East Park Energy Solar Project

DCO Application 010141

Submission by Phil Wayles on the Applicant's A1/B645 Junction Technical Note

Submission by Phil Wayles on the Applicant's Updated Outline Construction Traffic Management Plan (oTCMP)

Client
BSSL Cambsbed 1 Ltd
Project
East Park Energy
Drawing Title

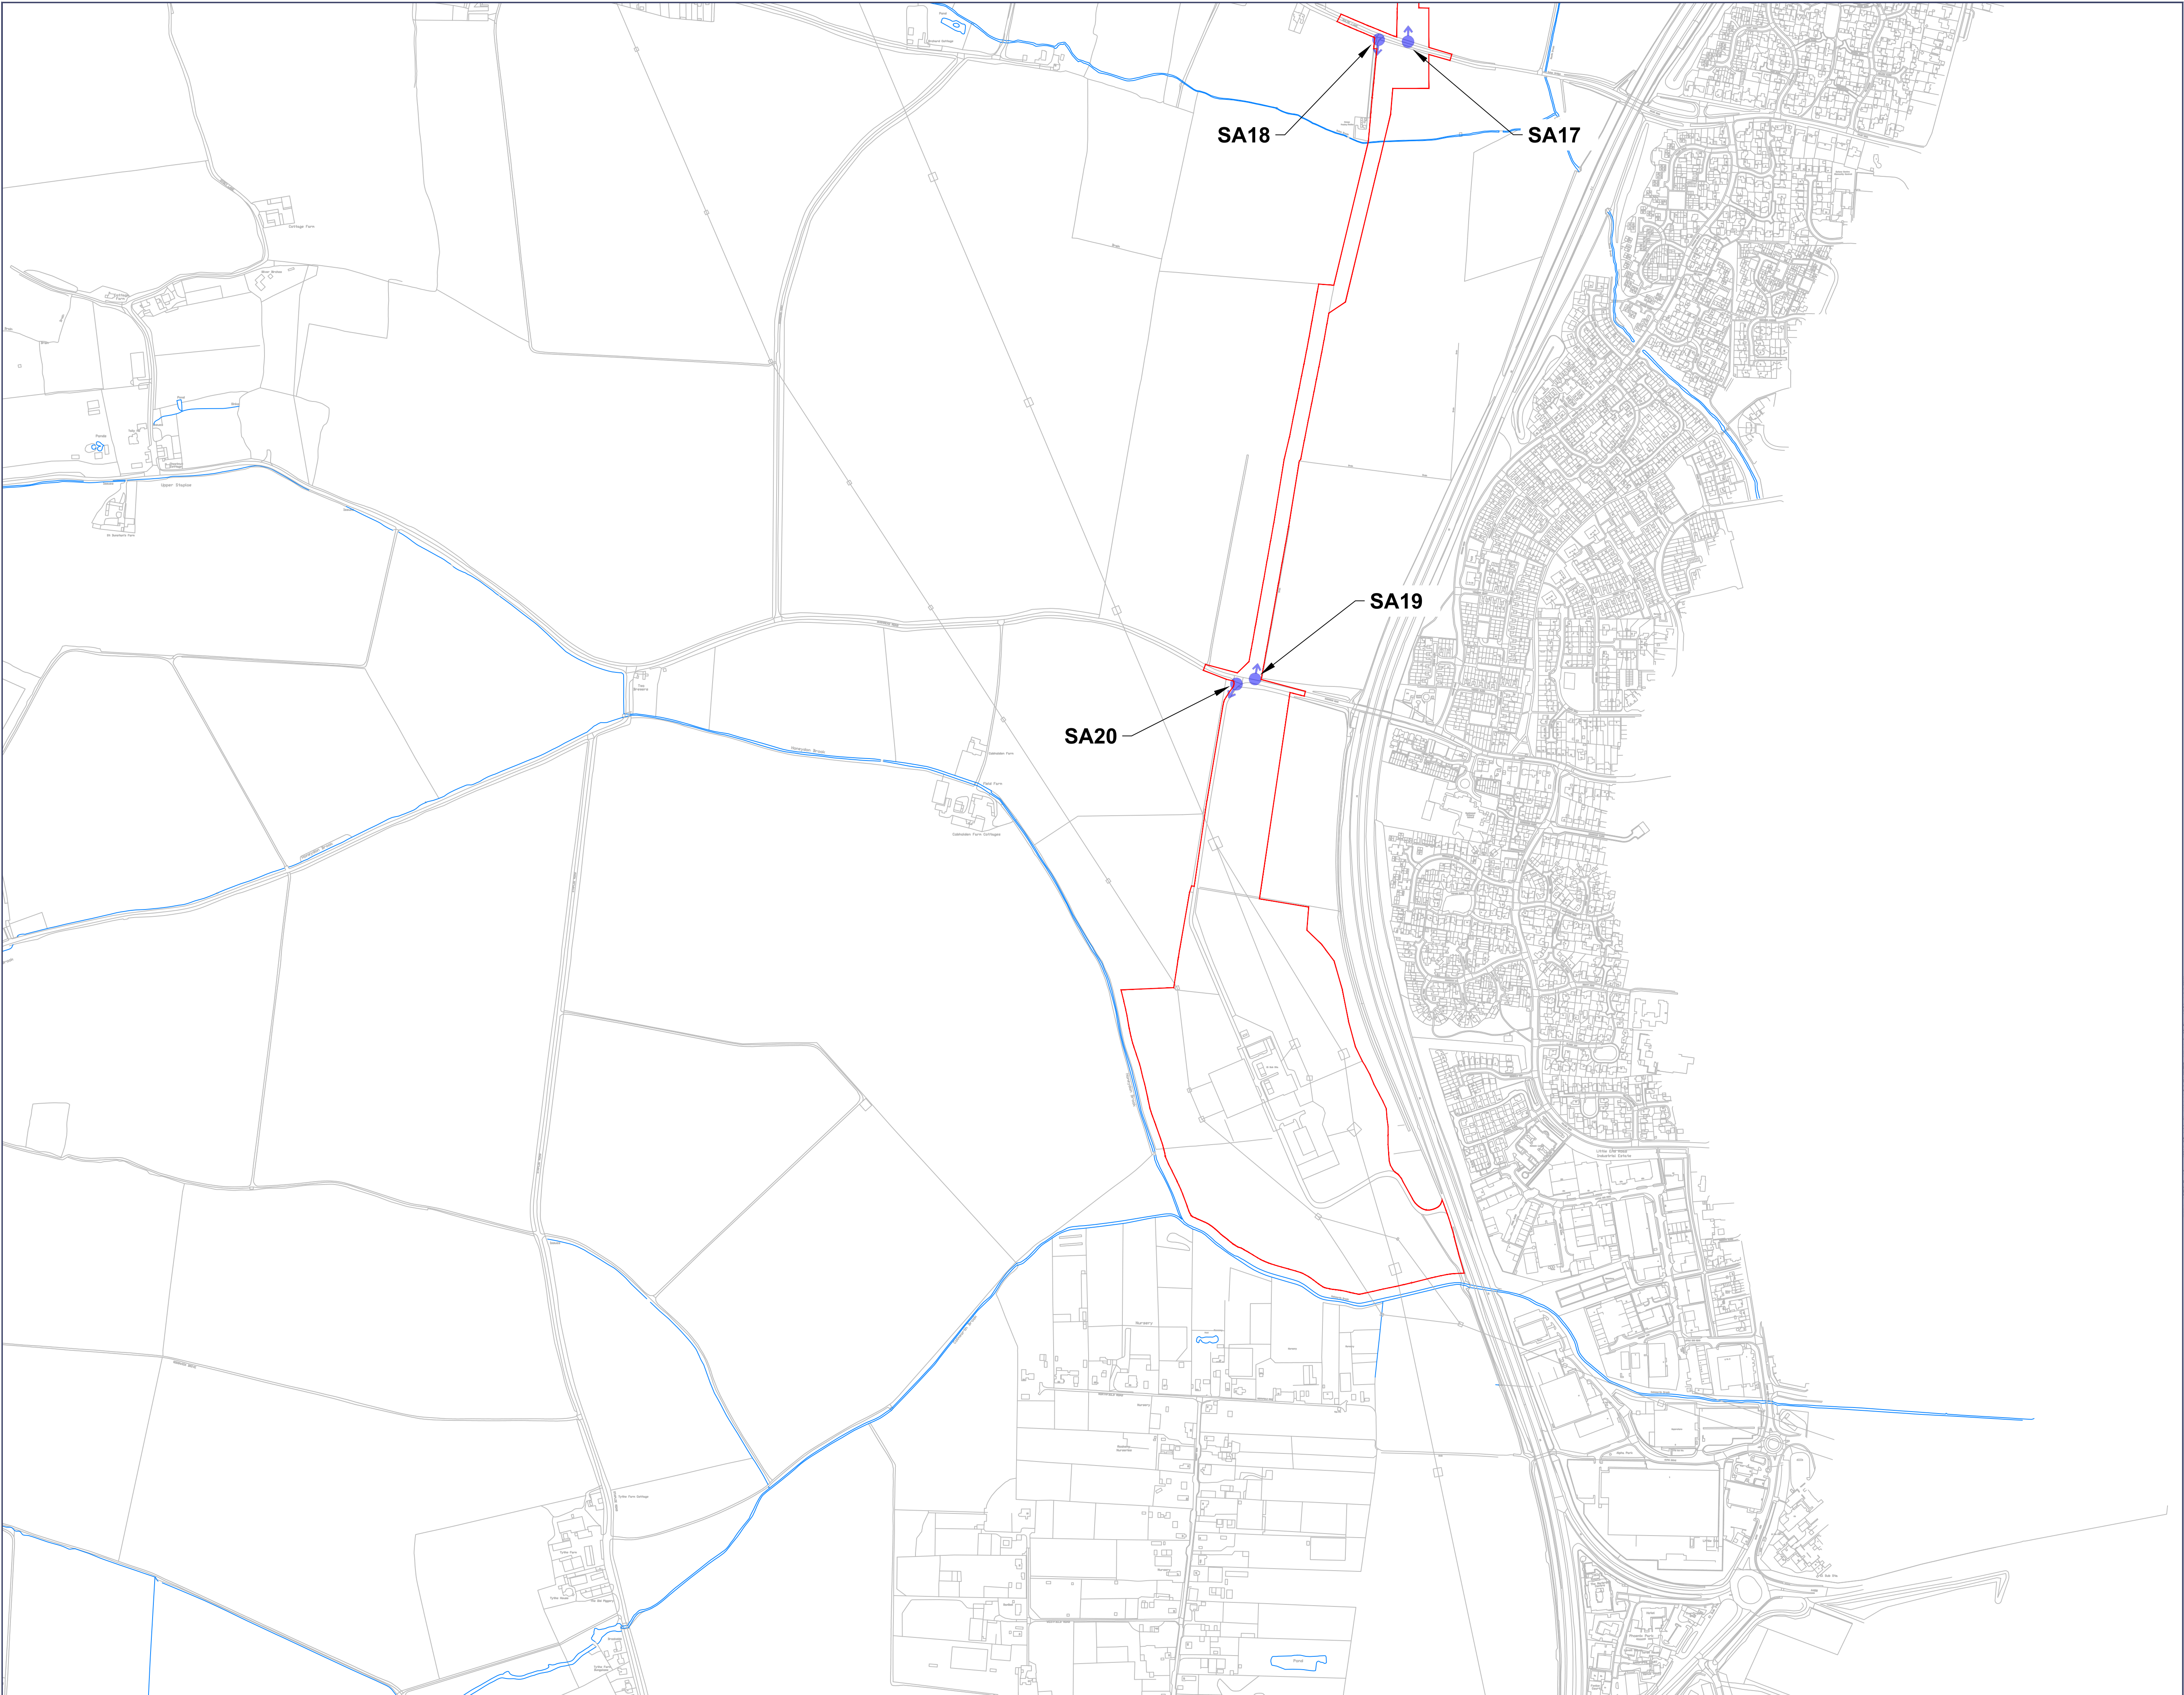
Para 5.1.11 states "*Site B also has a number of site access junctions which require construction traffic to use short sections of the public highway along Great Staughton Road (SA03, SA04, SA05, SA06) and Green End (SA09).*" Also with reference to Para 5.2.1 and 5.2.2, the Applicant's traffic-flow diagrams appear to assign only minimal construction vehicle movements to the SA03–SA06 Great Staughton Road accesses and SA09 at Green End, despite those accesses serving substantial areas of Site B proposed for solar panel development and two of the satellite compounds. The Indicative Site Access Drawings in Appendix D also include swept path tracking diagrams for these accesses. The application does not transparently explain how the

site areas accessed by SA03, SA04, SA06 and SA09 can be constructed with such limited access movements especially as road widening is required at some locations. This creates uncertainty as to whether the traffic assessment materially understates localised construction activity on Great Staughton Road and Green End Road. The satellite compound near Green End should be accessed by an internal haul road, rather than by public highway and site access SA09. This emphasises the oCTMP does not explicitly and clearly set out which existing roads will be used by construction traffic, nor does not show comprehensive details for as requested by the Local highways Authorities and several IPs. A Construction Traffic Permitted Routes / Restricted routes must be prepared for the whole area bounded by the A1, A14, Bedford to the south and B660 / Swineshead Road to the west.

Para 5.1.13 has been updated to “*Minor road widening works will also be required along Spring Hill Road, and potentially Great Staughton Road, to facilitate the two-way movement of HGVs between access SA12 and access SA10 during the construction phase.*” As described at the ISH, this requires HGV construction traffic to travel on sections of Great Staughton Road and Spring Hill Road between these 2 accesses (SA10 and SA12) rather than use an internal haul road between Sites B and C. The change to use a section of the public highway was introduced in the Stat Con documentation, although difficult to interpret. At Non-Stat Con, the Applicant intended to use the internal cabling corridor for temporary construction access (haul road). It is illogical and inappropriate to use and widen the existing public highway when a perfectly sensible alternative exists using an internal haul road to be built along the cable route between Sites B and C as shown on Figure 15 - Proposed Construction Access Strategy in Appendix C (see extract below). This plan indicates there is a temporary haul road along the cabling corridor route which is due to be removed post- construction. Mandating use of this section of temporary haul road would improve safety and limit damage to the existing roads by keeping large and heavy site vehicles off the public highway. Furthermore, there would be further disruption to traffic during the construction of the widening works, and this section of the public highway would be also used during the operational replacement works and decommissioning works. This disruption also applies to the road widening works required at several of the new proposed site accesses to accommodate the HGV swept path tracking shown on the Indicative Site Access Drawings.

Appendix D: Indicative Site Access Arrangement Drawings has been added. These show geometric design parameters for each access and crossing. Visibility splays and swept path tracking for rigid and articulated HGVs. The access / crossing designs, existing carriageway widths and fencelines are based on OS Mastermap data. The design should be based on topographical survey data, so the design details are based on accurate road location / width, roadside drainage features, road furniture such as traffic signs, trees and hedgerow position and width. These drawings therefore do not accurately show the extent of works and greater lengths of road widening and hedgerow trimming/removal to achieve the necessary visibility splays. The latter point was raised by the local highway authorities such as BBC in their LIR at Section 11.17 a) iii. The extent of hedgerow removal is already understated in the environmental assessment and impacts of the BNG calculation. Additionally, and as set out above, Sections 5.4.2 and 5.4.3 say the visibility splays at each proposed access are Design Manual for Roads and Bridges (DMRB) compliant. This requirement was requested by BBC at Section 11.17 (Matter 50) and this section highlighted that DMRB visibility splay standards were more onerous than those using Manual for Streets (MfS) criteria. However, some plans in Appendix D still show visibility splays including for Accesses SA14, SA15, SA17, SA18, SA19 and SA20 designed to MfS standards. This potentially makes the access less safe and would require greater lengths of hedgerow removal or trimming.

The very fact that some roads need widening (including to construct several site accesses) proves this local road network is unsuitable for the intended construction vehicles. Also, details are not provided for the traffic management arrangements and traffic diversion routes during construction (including to build the accesses and widen roads).
